RE: Responses to Comments – Technical Review 2  
White Barn – Chick-Fil-A  
Highway 9 and Soper Hill Road, Marysville, Washington 98258  
Permit No. PA23-019 / Our Job No. 22579

We have revised the plans and technical documents for the above-referenced project in accordance with your comments dated May 3, 2024. The following outline provides each of your comments in italics exactly as written, along with a narrative response describing how each comment was addressed:

5/28/2024 11:42:24 AM Autodesk Docs://WA\_05328\_Hwy 9 & Soper Hill Rd\_2023.3\_FSR#05328\_Hwy 9 & Soper Hill Rd\_ARC.rvt 10-SE-05328-A-101-PATIO PLAN AND DETAILS

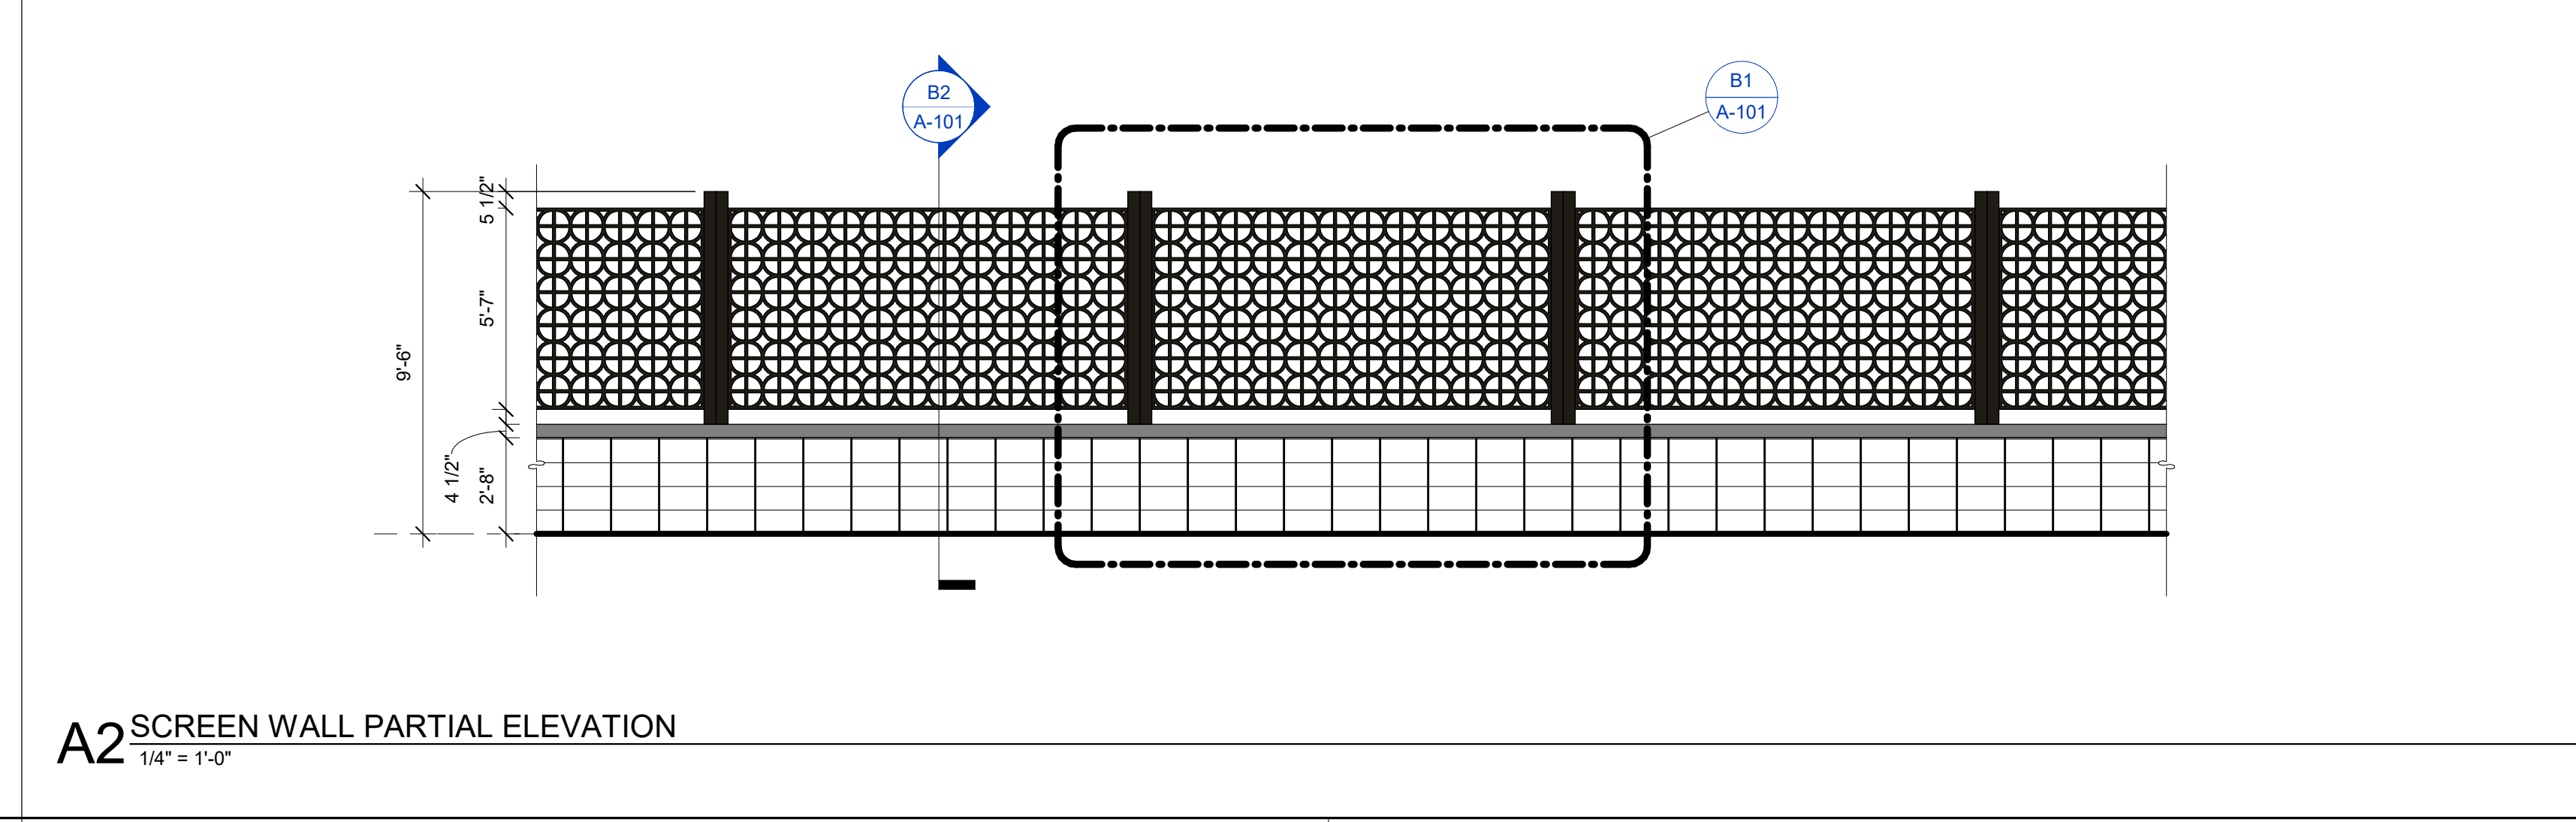
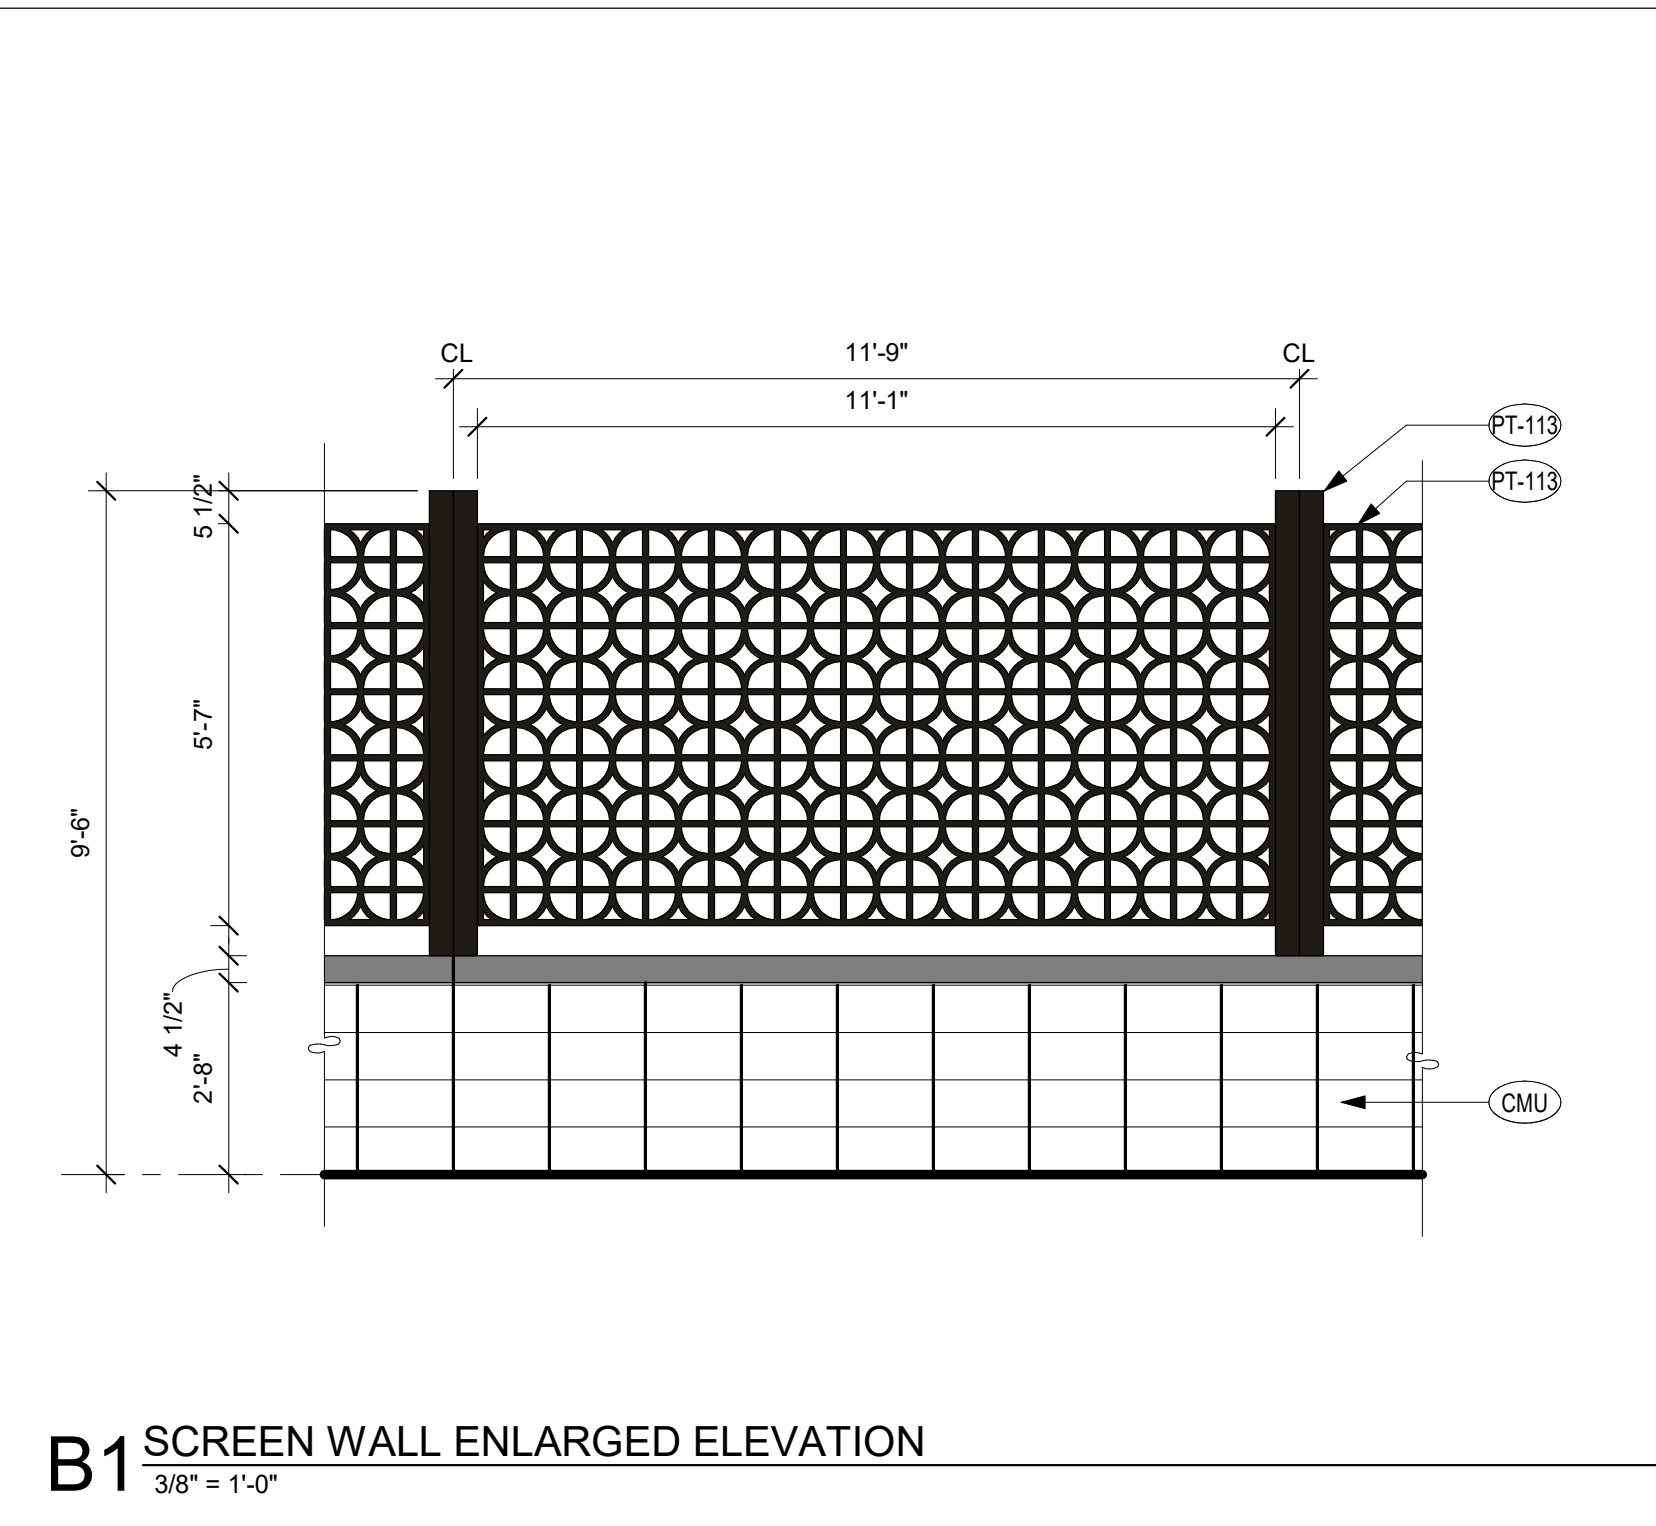
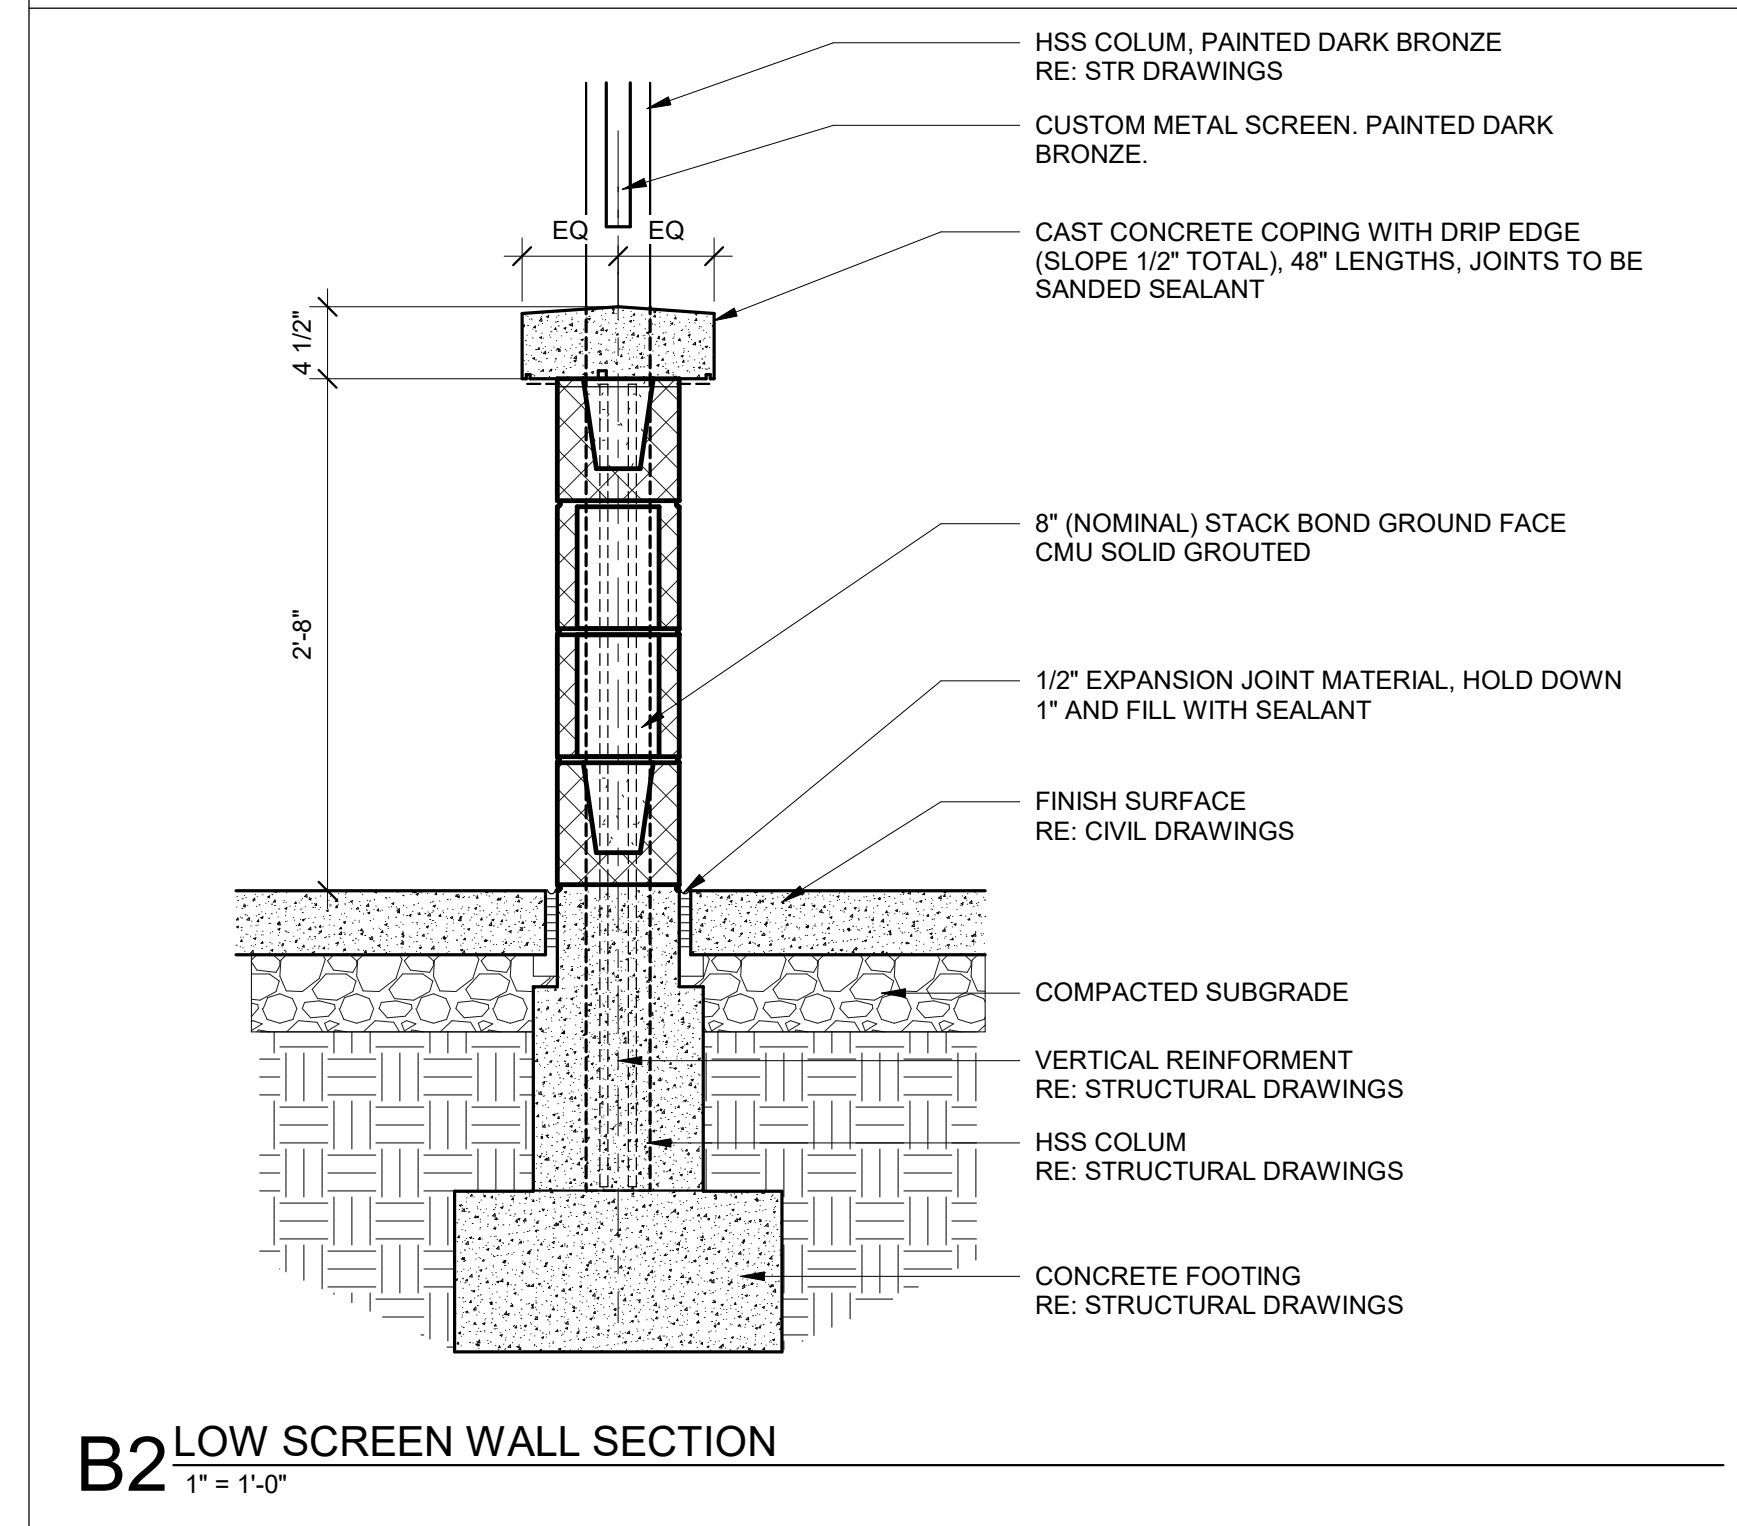
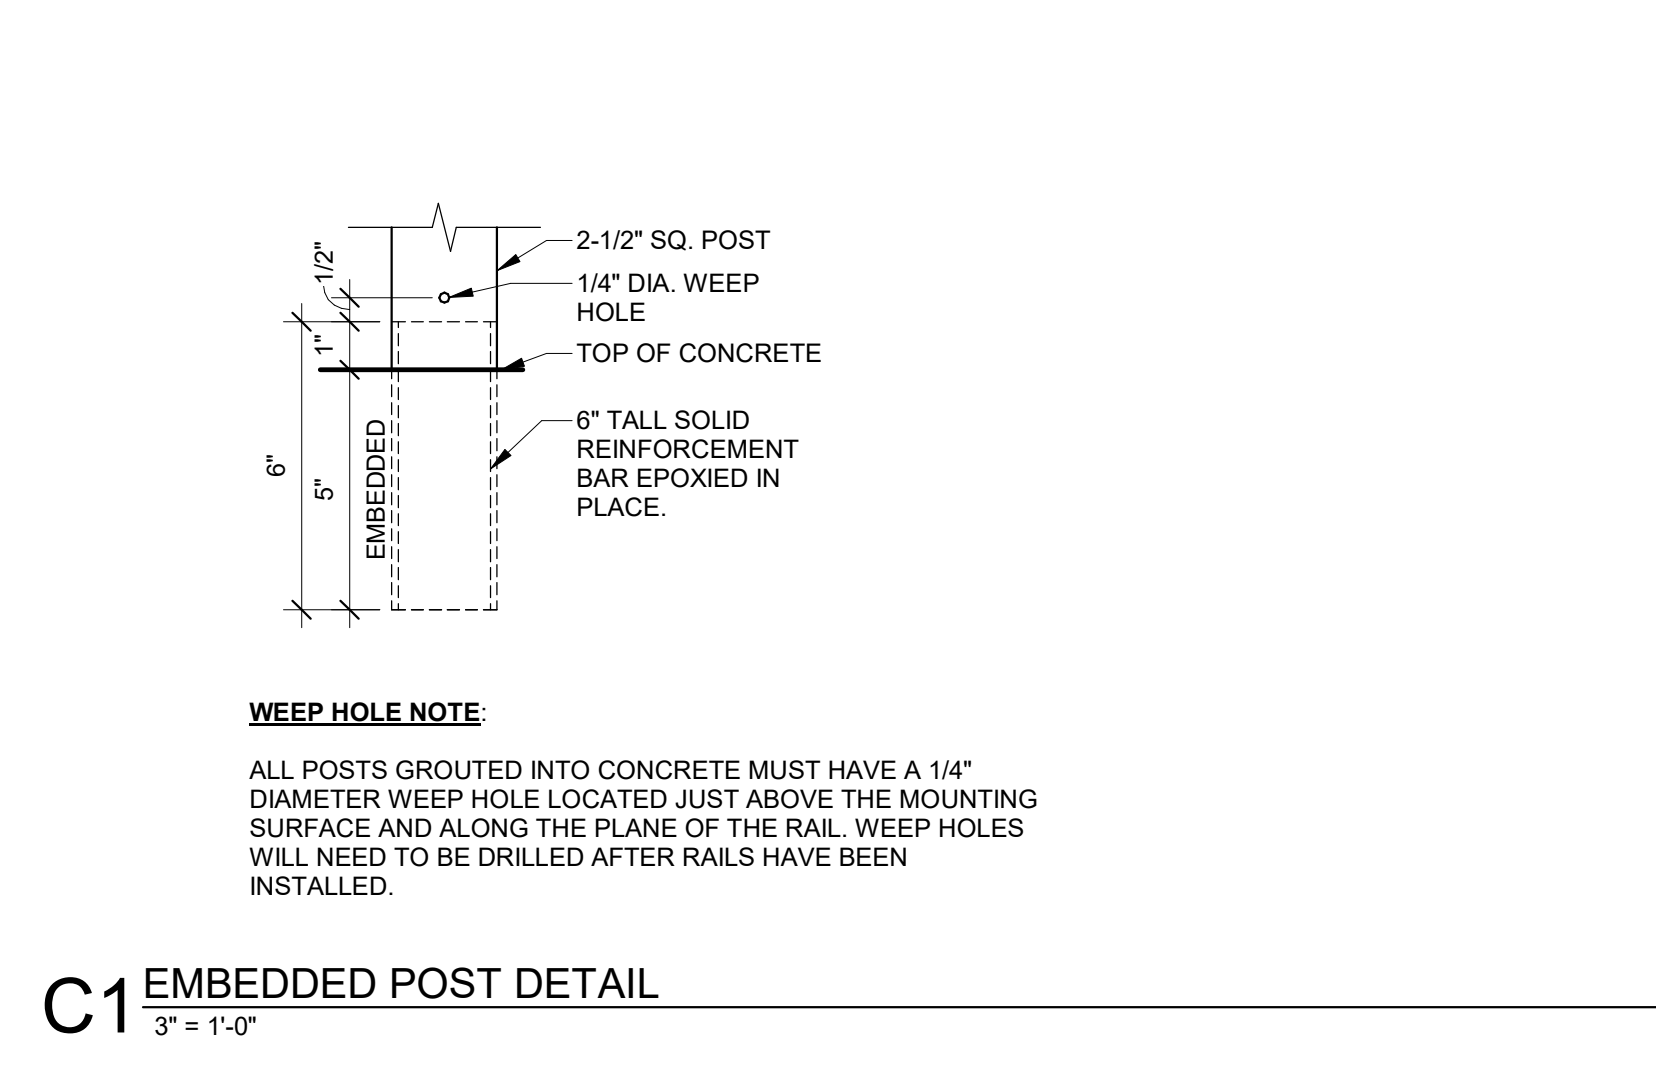
*In discussion with the Director, the City is willing to reduce the landscape buffer along Soper Hill Road and 87th Avenue NE to a 10' L2 buffer, with a decorative screen wall that is constructed with materials that are complimentary of the proposed restaurant. Colored architectural drawings and a revised screen wall will need to be submitted for Director approval. At this time it is unclear if the two examples provided would meet this criteria. The Renton, WA example would not be acceptable.*

Sheet A-101 is provided with this submittal for the proposed screen wall design semi-opaque from the ground to a height of 3 feet with visual obstruction above the opaque portion using decorative metal screening.
